Your ref: SSD 9667
File no MC-18-00004

SSD 9667 - Light Horse Interchange Business Hub, Eastern Creek

Blacktown Council's submission to SSD 9667 - Light Horse Interchange Business Hub, Eastern Creek

Drawing Name: **Landscape Plan**
PRELIMINARY
Scale: 1:500 @ A1
Job Number: **SS18-3892**
Drawing Number: **101**
Issue: **G**

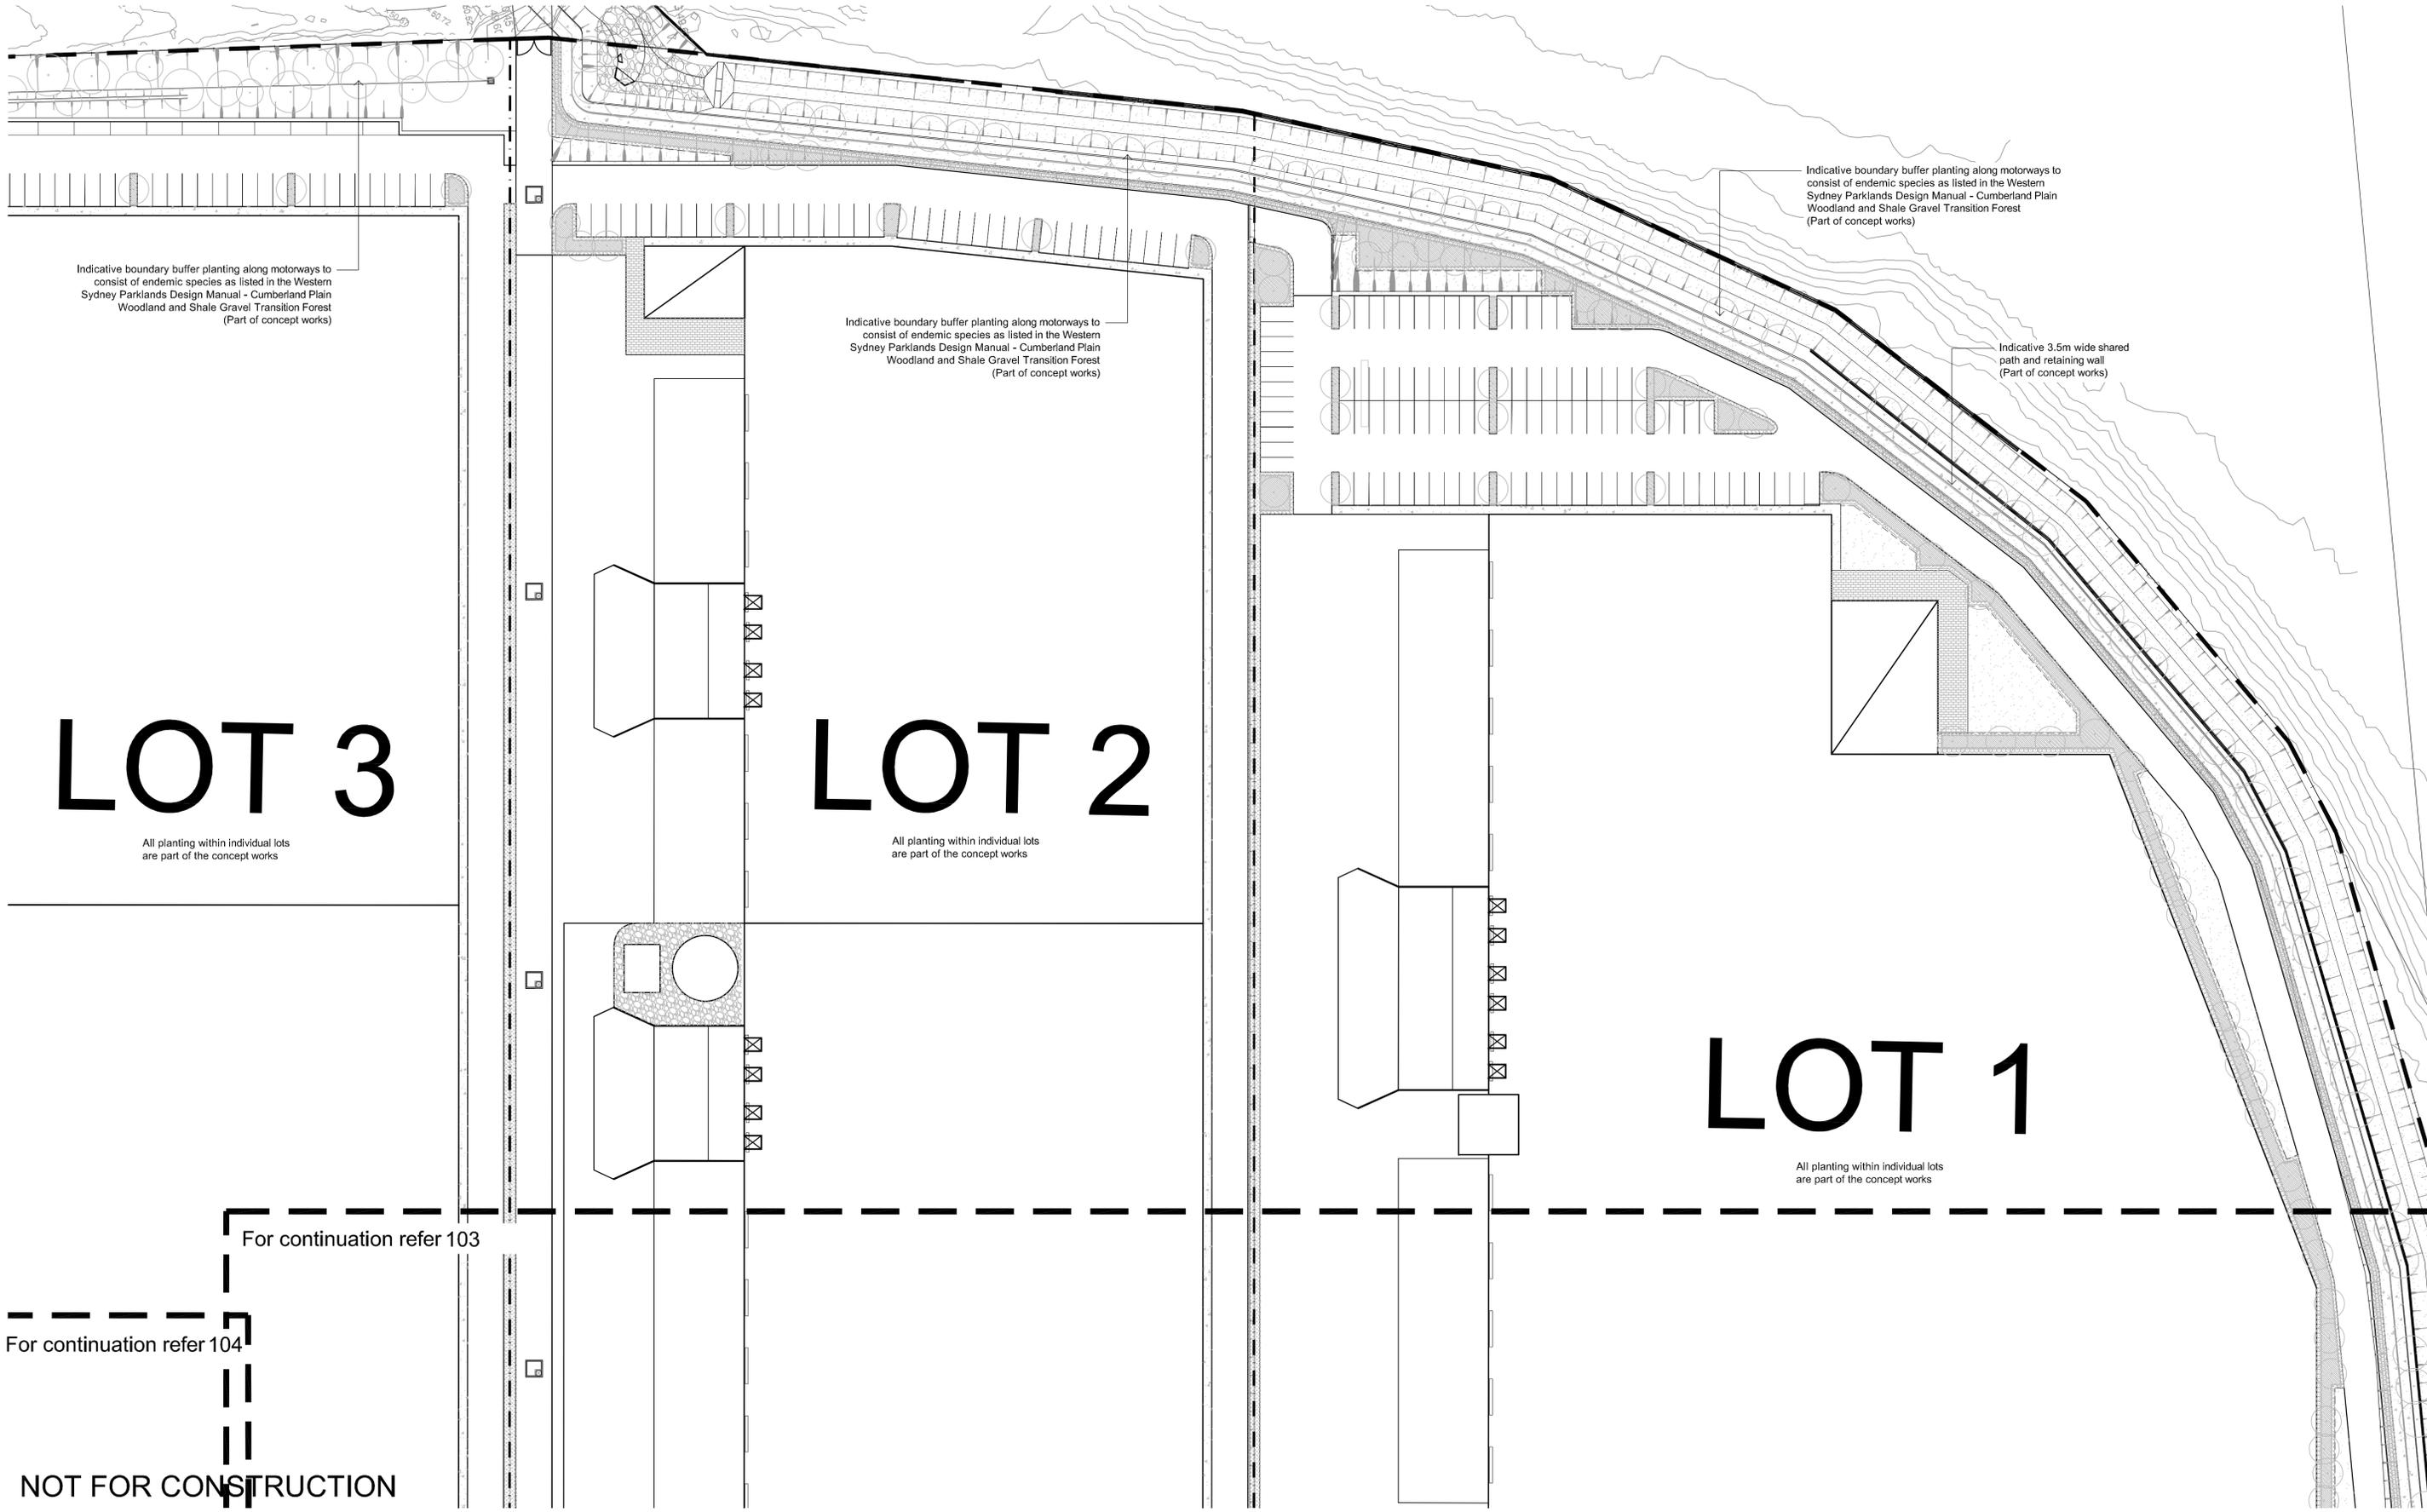
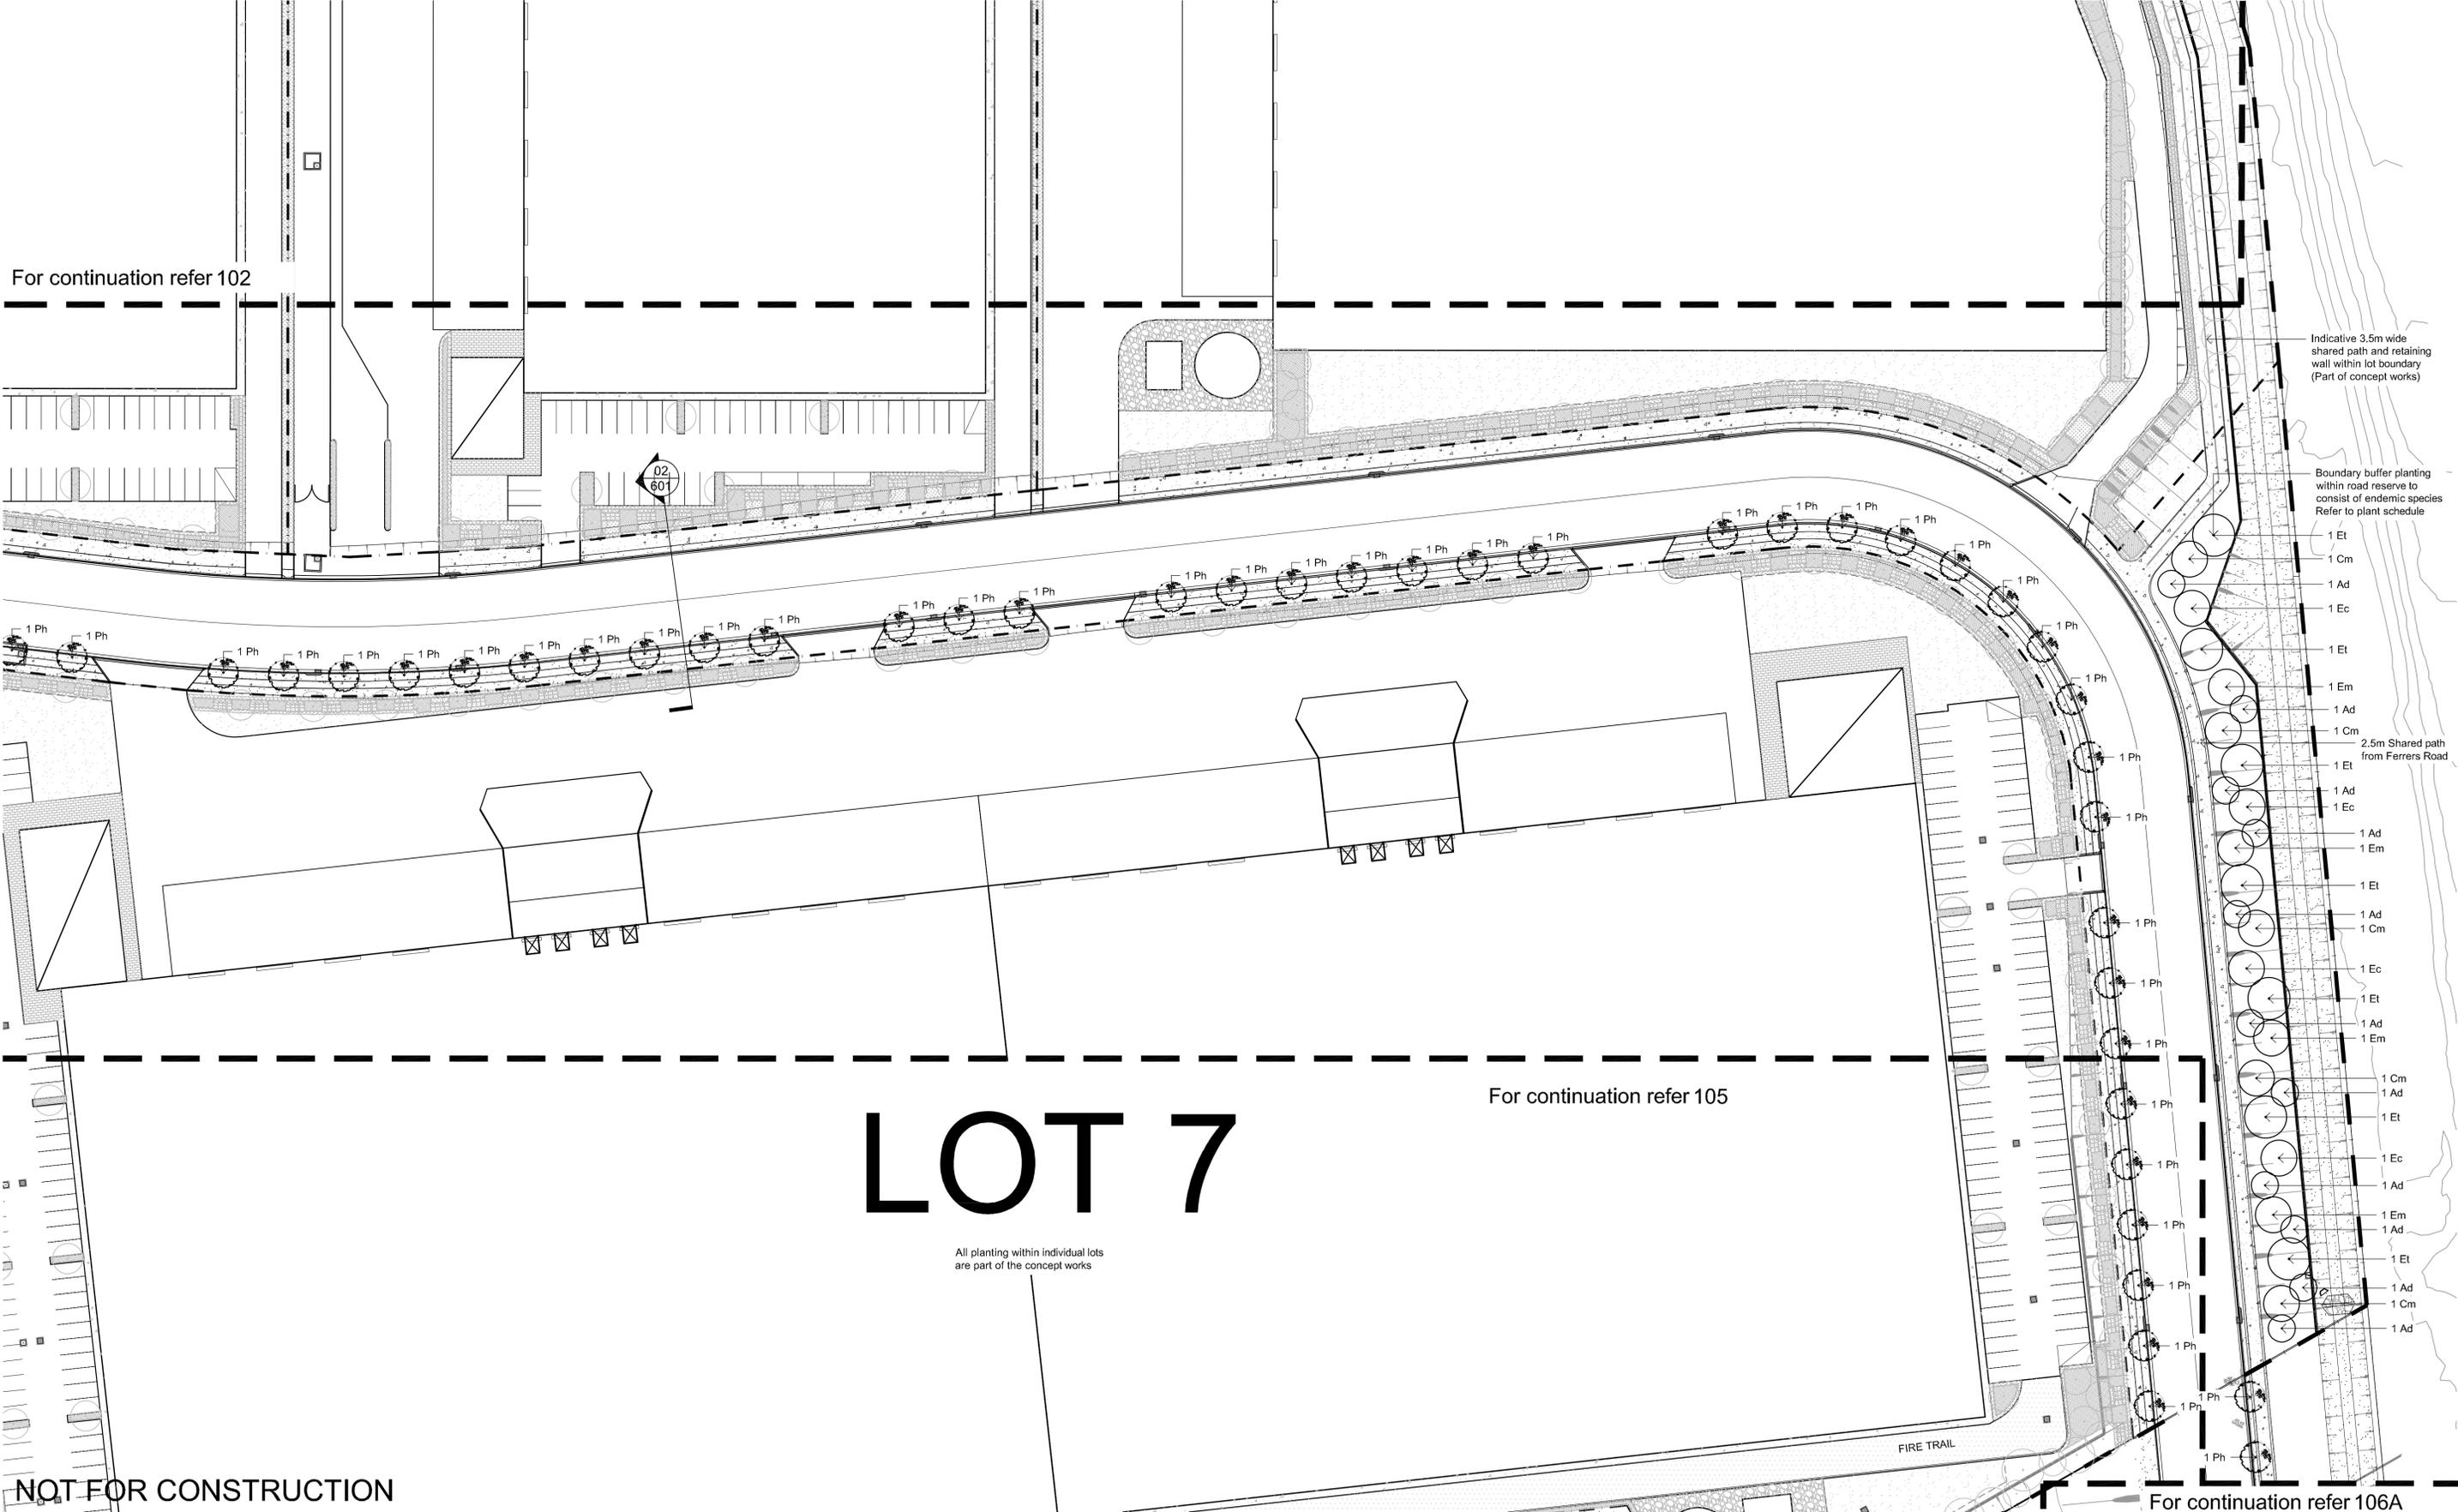
- 5. Provide a revised landscape plan by Site Image Job number SS18-3892 dated 24/1/2020 to extend the landscape works for the vegetated riparian corridor to a minimum average of 20 m outside the creek banks of the relocated Eskdale Creek up to and including the confluence with Reedy Creek. Where 20 m cannot be achieved on one side, it is to be compensated on the other side of the creek. The vegetation is to be generally in accordance with the Biodiversity Development Assessment Report (BDAR) – prepared by Eco Planning 2019.
